From: Martyn White <Martyn.White@arun.gov.uk>
Sent: 01 November 2019 09:36
To: Planning.Responses <Planning.Responses@arun.gov.uk>
Cc: Amber Willard <Amber.Willard@arun.gov.uk>
Subject: BR/258/19/L

BR/258/19/L

ROYAL NORFOLK HOTEL – EXISTING STAFF ROOMS ON GROUND FLOOR SCALE 1:50 AT A4

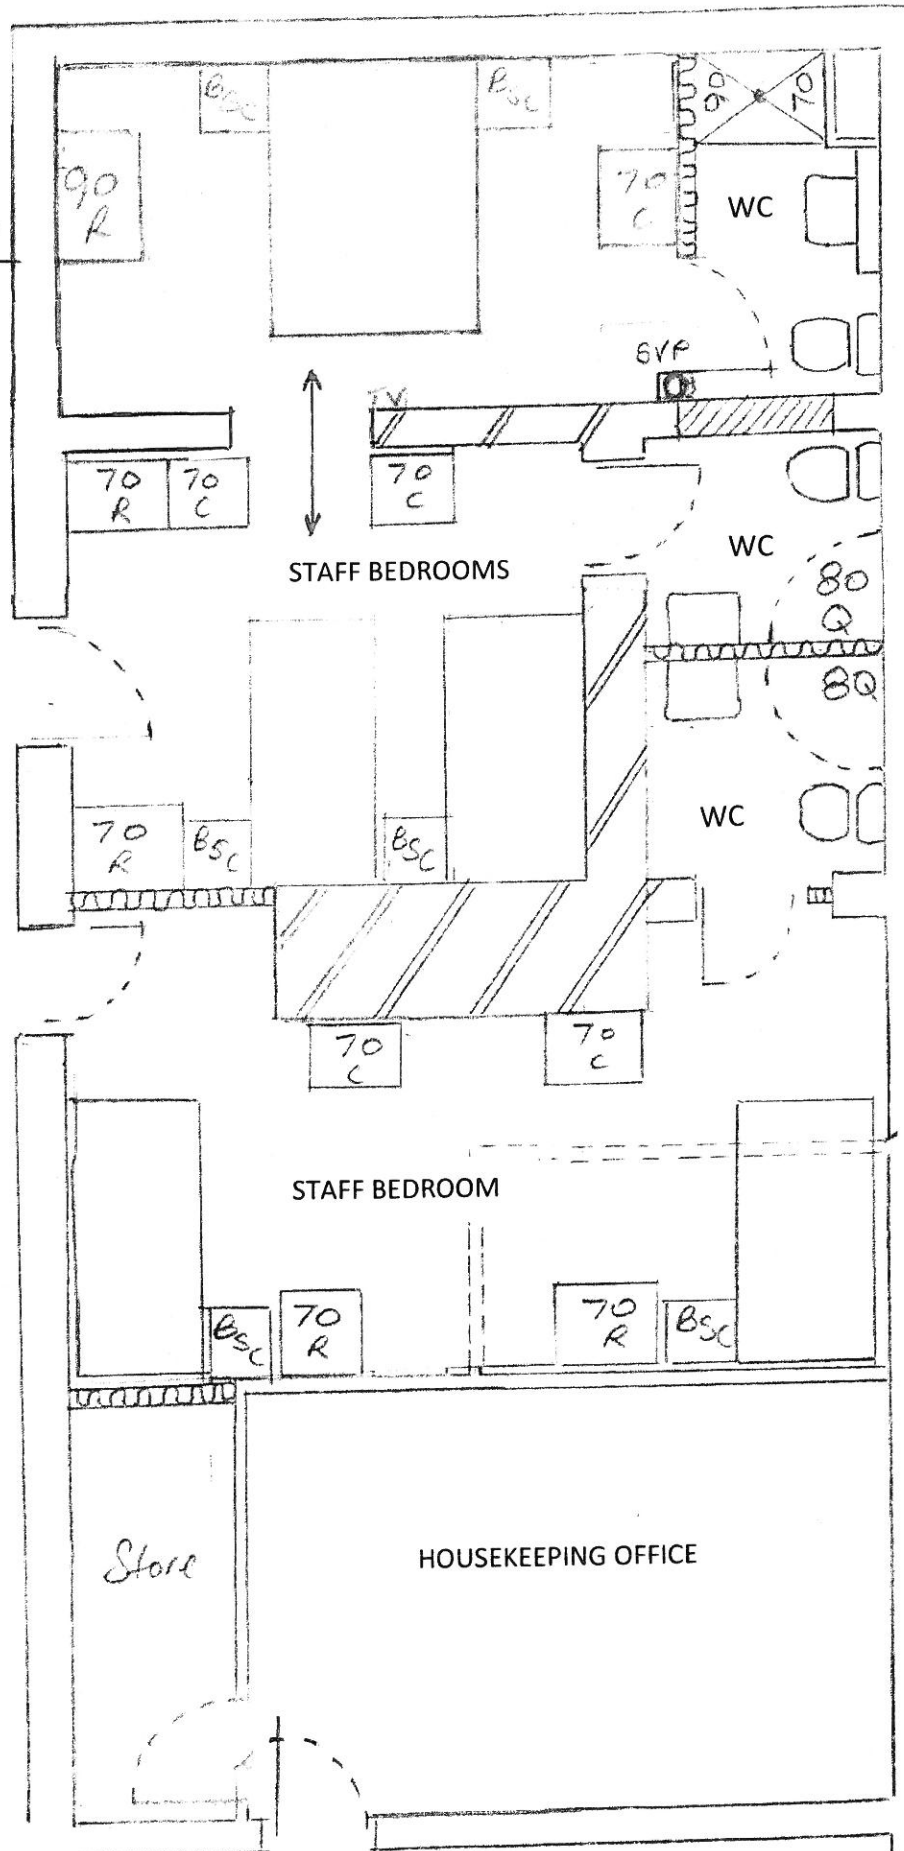
The proposed works relate to the introduction of an additional door to a rear, side elevation in close proximity to two existing doors. The scale of the works is such that it will not have an impact upon the significance of the listed building. This is on the basis that the new door should match the neighbouring ones in terms of appearance and colour.
